I am writing as a parent of a child that attends Darlington Public School regarding the proposed development by the University of Sydney, MP 07_0158 – Abercrombie Street Precinct, Syd Uni. Darlington Public School is an inner city school servicing the suburbs of Chippendale, Darlington and parts of Redfern. The school is directly adjacent to the western border of the project.

Drawing title
GROUND FLOOR PLAN

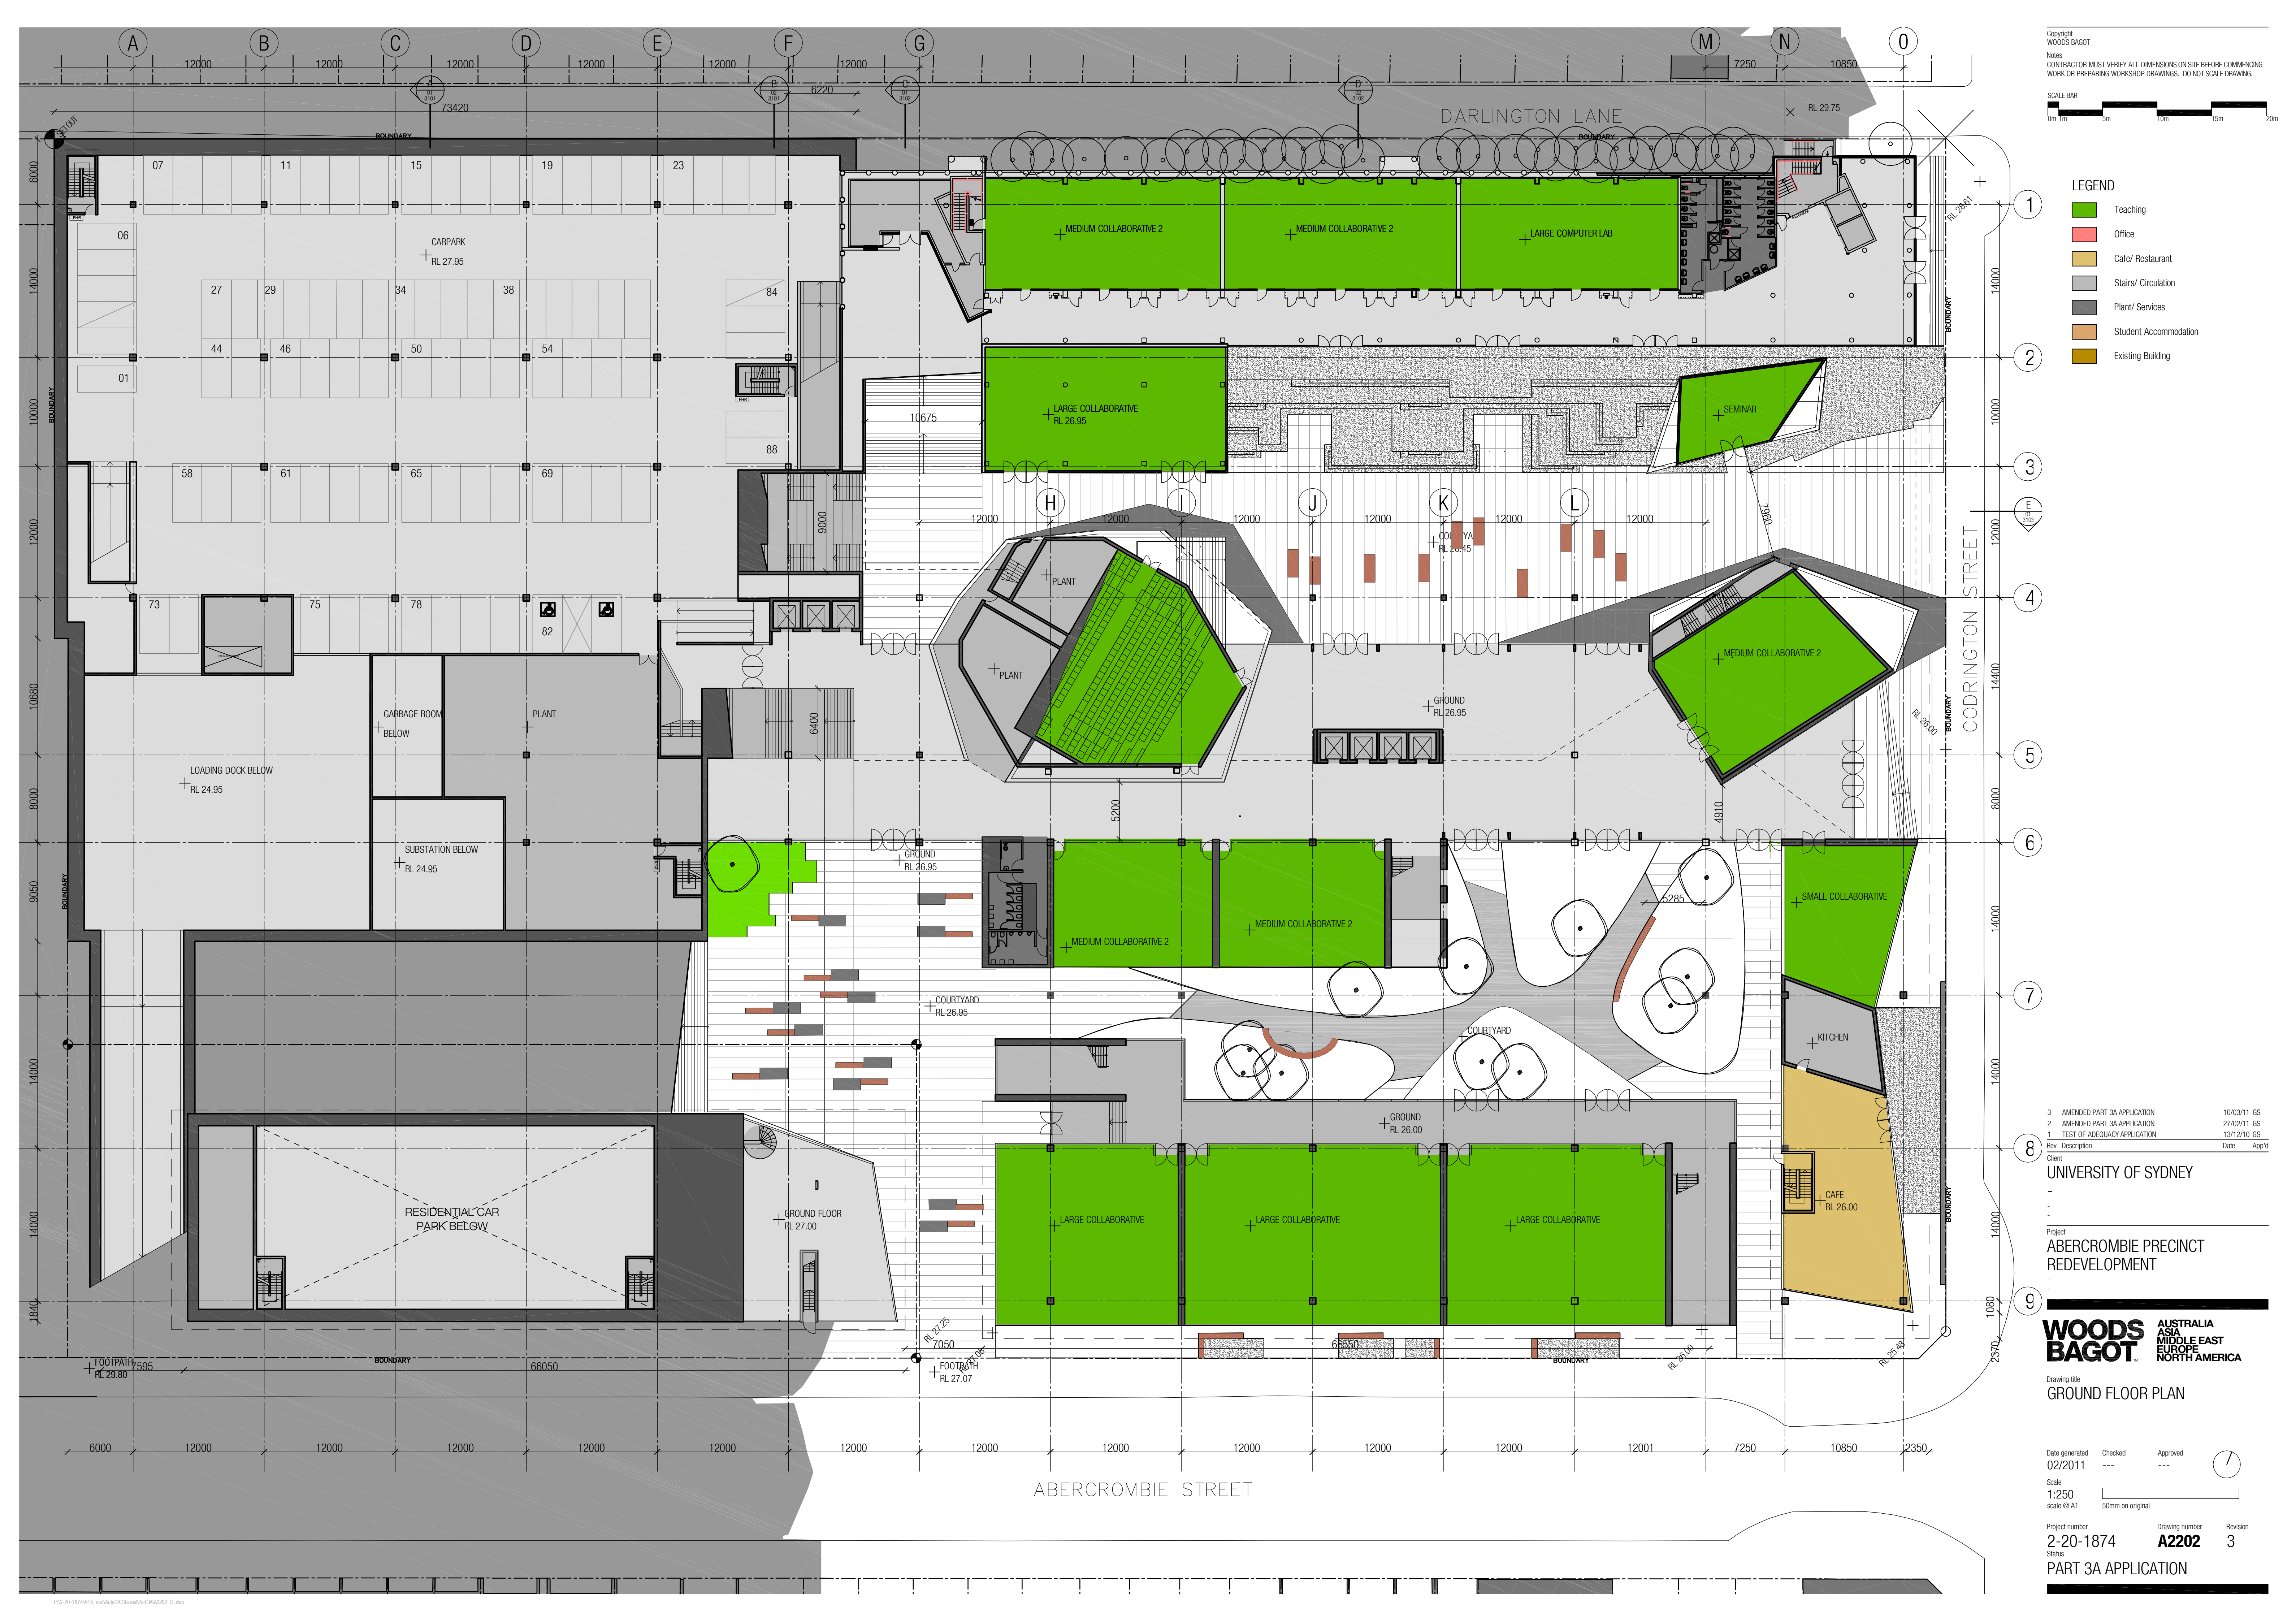
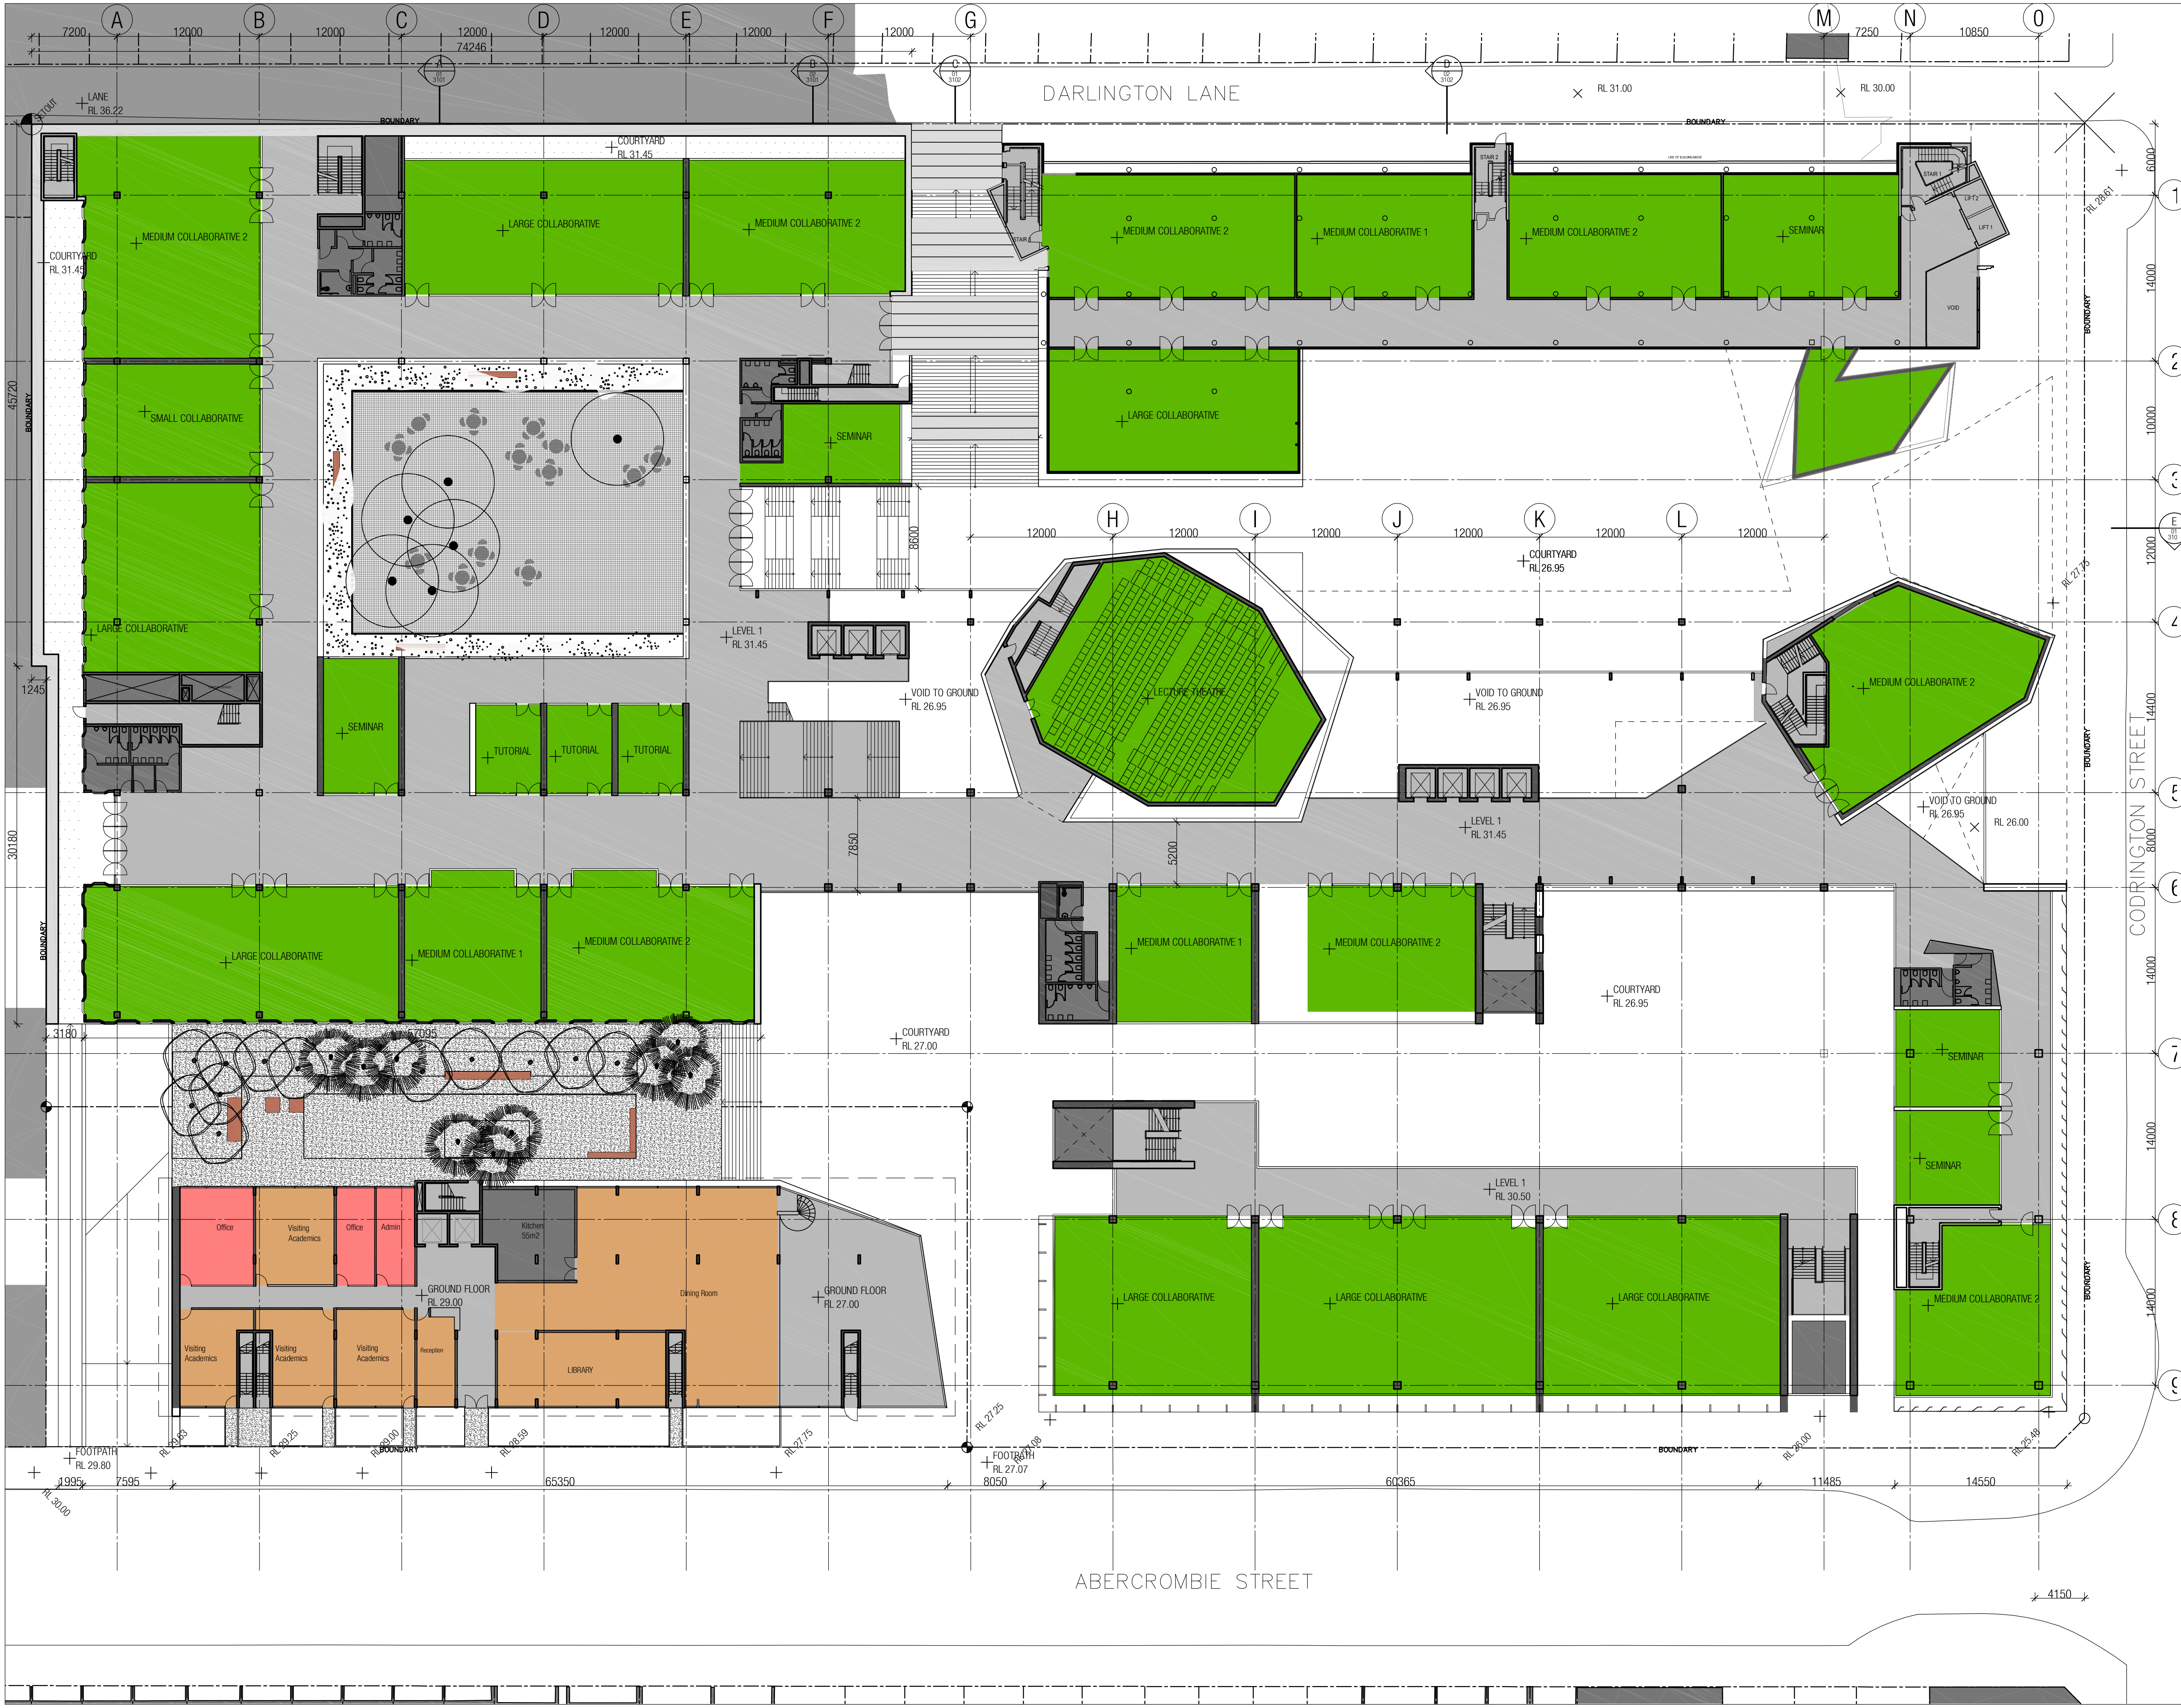
The proposed access point for the site is on Abercrombie Street and is directly adjacent to the school classrooms on the North East border of the school site. Such a location for the access point for trucks would:

- produce unacceptable levels of noise and vibration in the school classrooms that border that entrance – Years 2, 4, 6 and both kindergarten classes. This is also particularly significant for the 2 kindergarten classrooms which face the development to the north with only glass panels and glass doors on that side.
- create an unsafe corridor for school children and parents that walk, or ride to school along Abercrombie Street (north side). This includes many unaccompanied but young children entering and leaving the school.
- create an unsafe car drop off and pick up point on Abercrombie Street (the main drop off point at the school).
- reduce the drop off and pick up point area for numerous children who are transported by car.

As per the current development plan, the proposal calls for an underground car park to be built for the student accommodation and University staff. The car park will accommodate 185 car spots, and its entrance will be on Abercrombie Street, at approximately the same point of the construction access.

The concerns raised above about the access point to the construction site are the same for this car park access point increasing the risk to school children's safety, in an area that has already been highlighted through the respective organisations (Council, Police, and RTA). The increased traffic flow and access point are an unacceptable risk to the children who attend the school. There is no justification for this level of risk to a school community, particularly as the University has another street frontage without school or residential issues (the University being the only stakeholder for Codrington Street) and an access street internal to project (Darlington Lane).
